From: Simon Davis
Sent: 28 June 2017 17:27
To: Planning.Responses
Subject: FW: BE/71/17/PL - Wickes, Bognor Drainage Scheme

From: Paul Cann
Sent: 28 June 2017 10:48
To: Simon Davis
Subject: RE: BE/71/17/PL - Wickes, Bognor Drainage Scheme

SW PACKAGE PUMP

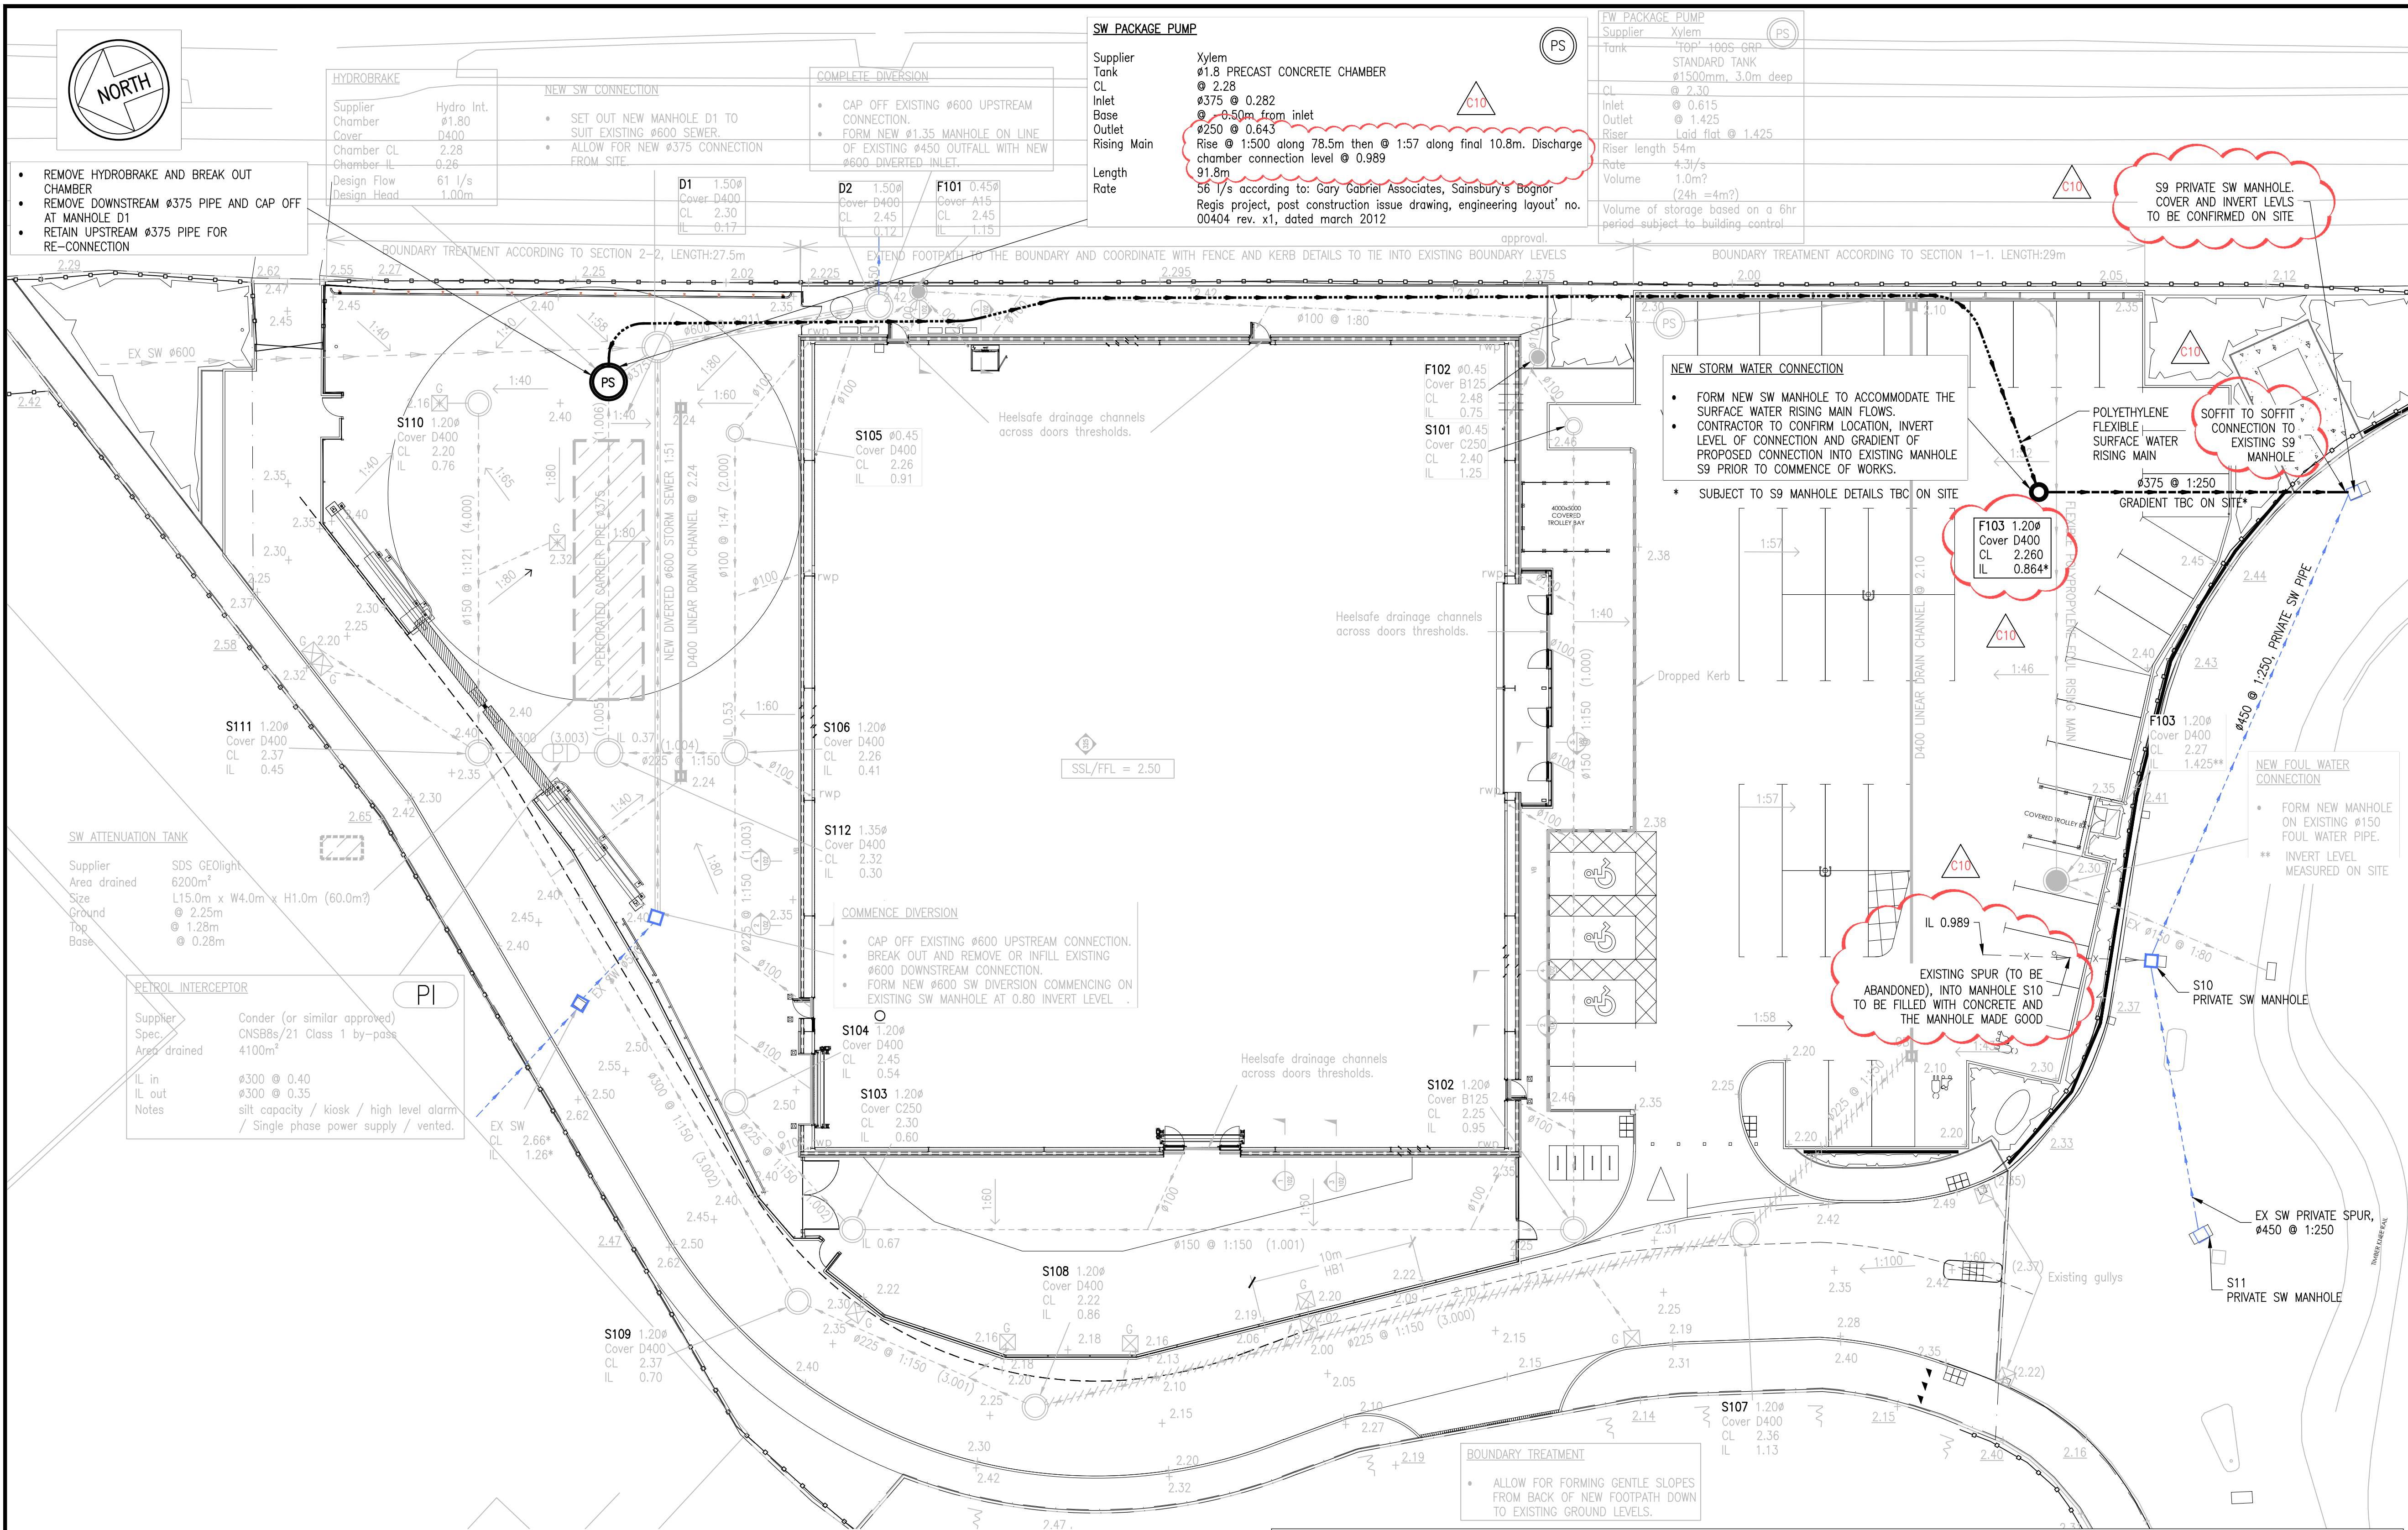
Tim mentions that the existing system at Wickes is pumped. As far as I am aware this is not the case, and there is no mention of a pumping station on the original proposals. The original intention was always to drain by gravity, either to the network rail culvert or to the Sainsbury system. I don't have an issue with either option (with a discharge by gravity), but the pumping is my concern, as it is not sustainable from a drainage point of view.
